From: Contact Centre (CRM) <contact@ribblevalley.gov.uk>
Sent: 09 December 2022 10:50
To: Planning
Subject: Planning Application Comments - 3/2022/1055 FS-Case-470729217

Planning Application Reference No.: 3/2022/1055

Address of Development: 59 Mellor Brow

Proposed Side Elevation

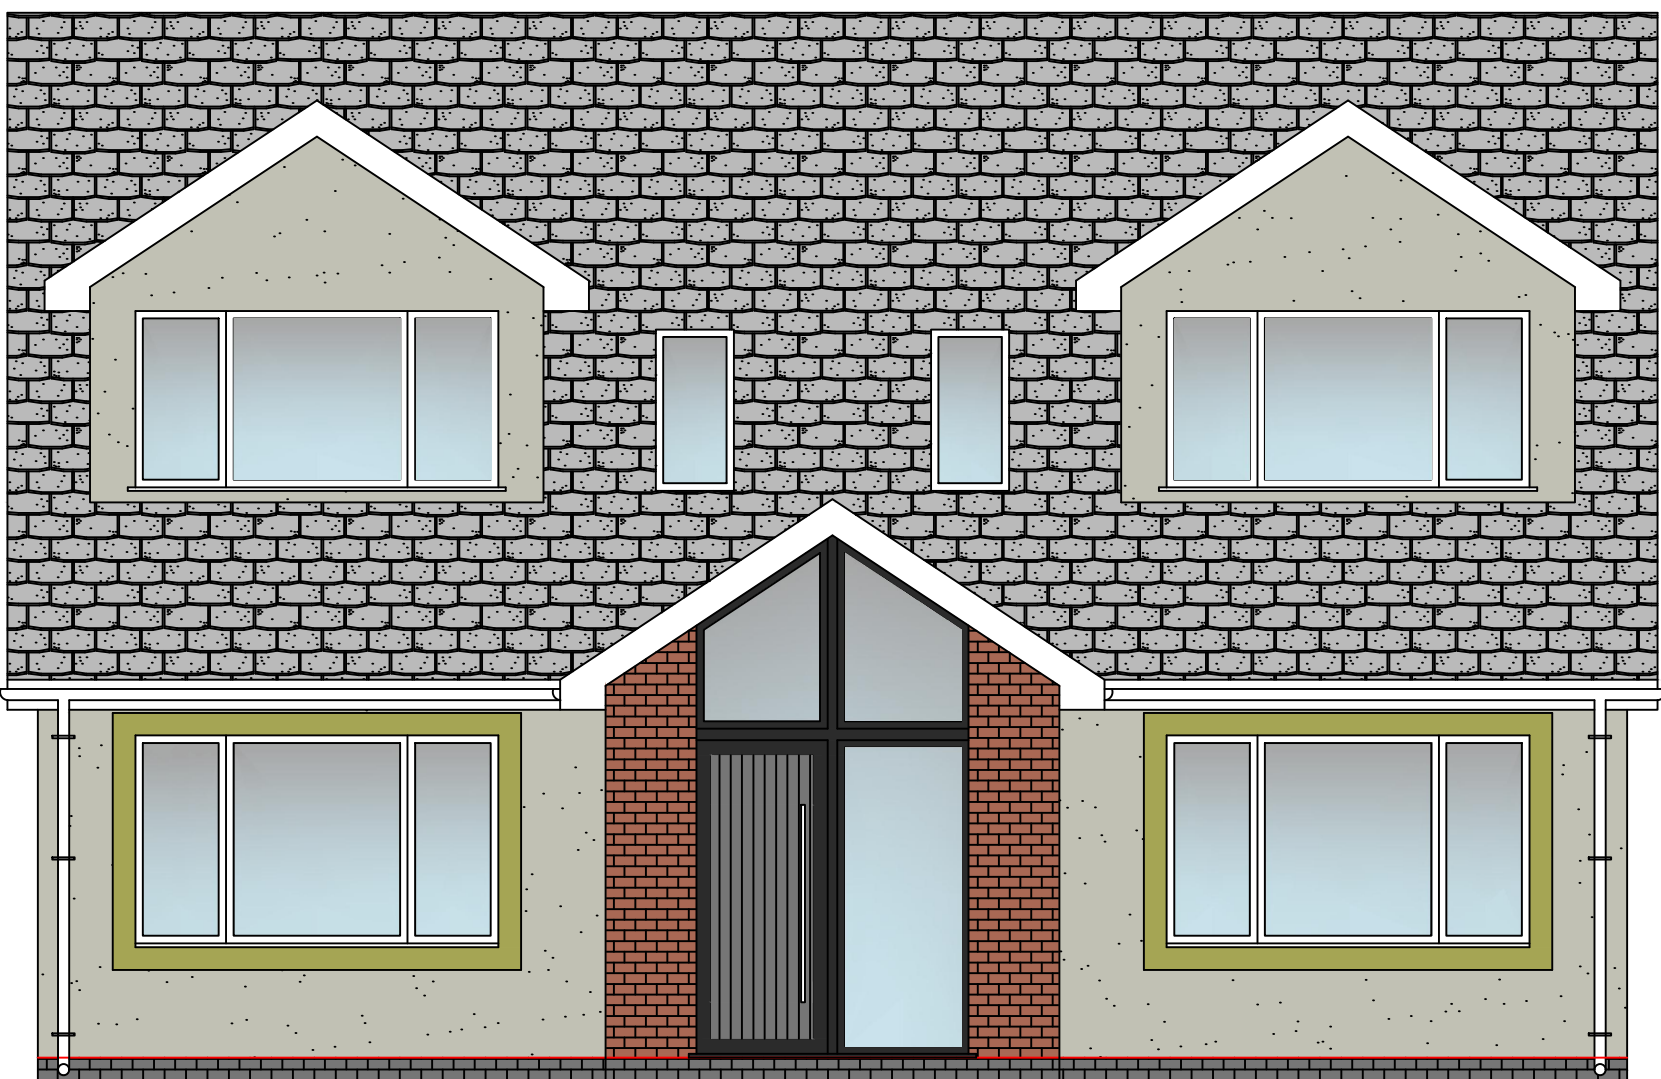
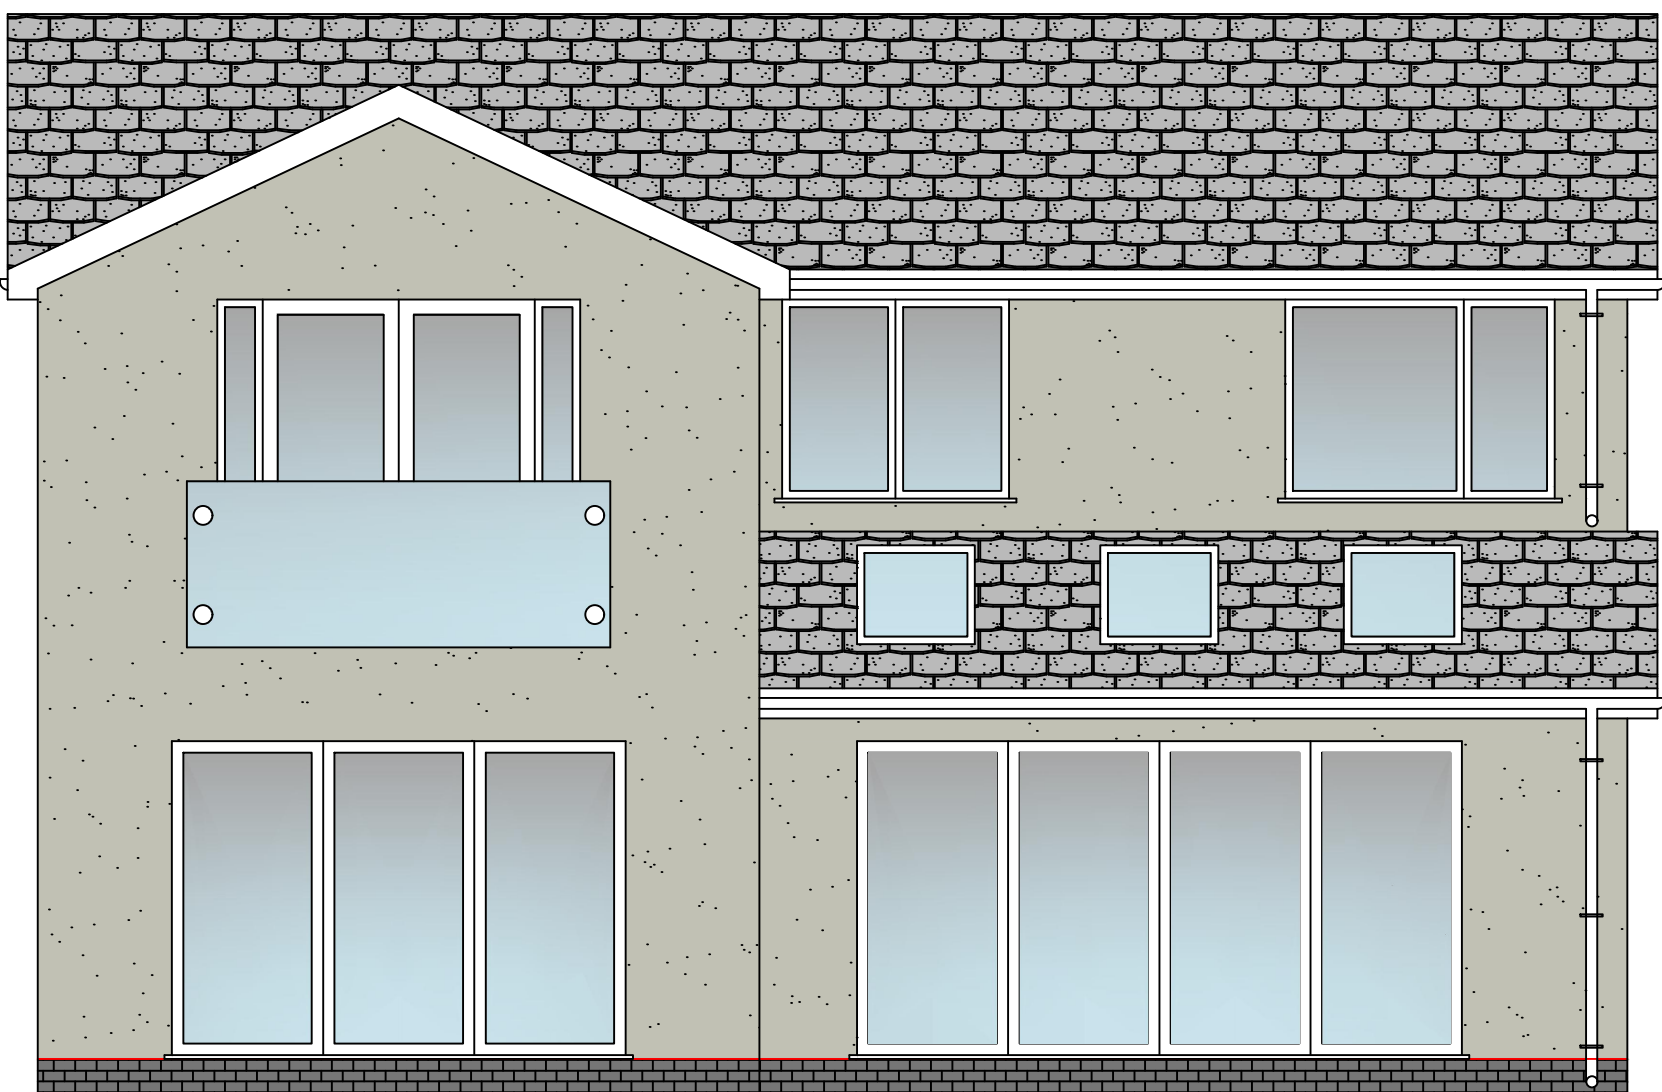
[REDACTED] The application drawing showing the west facing side elevation is misleading in that it does not show the ground sloping away from the house. The ground floor of [REDACTED] is already some 1.7m [REDACTED] and less than 4m away. The sloping nature of the site and the difference in ground floor levels between no. 59 Mellor Brow and [REDACTED] has the effect of creating a 3 storey high extension with a massive gable wall, more appropriate to an industrial site than Mellor Village's rural location.
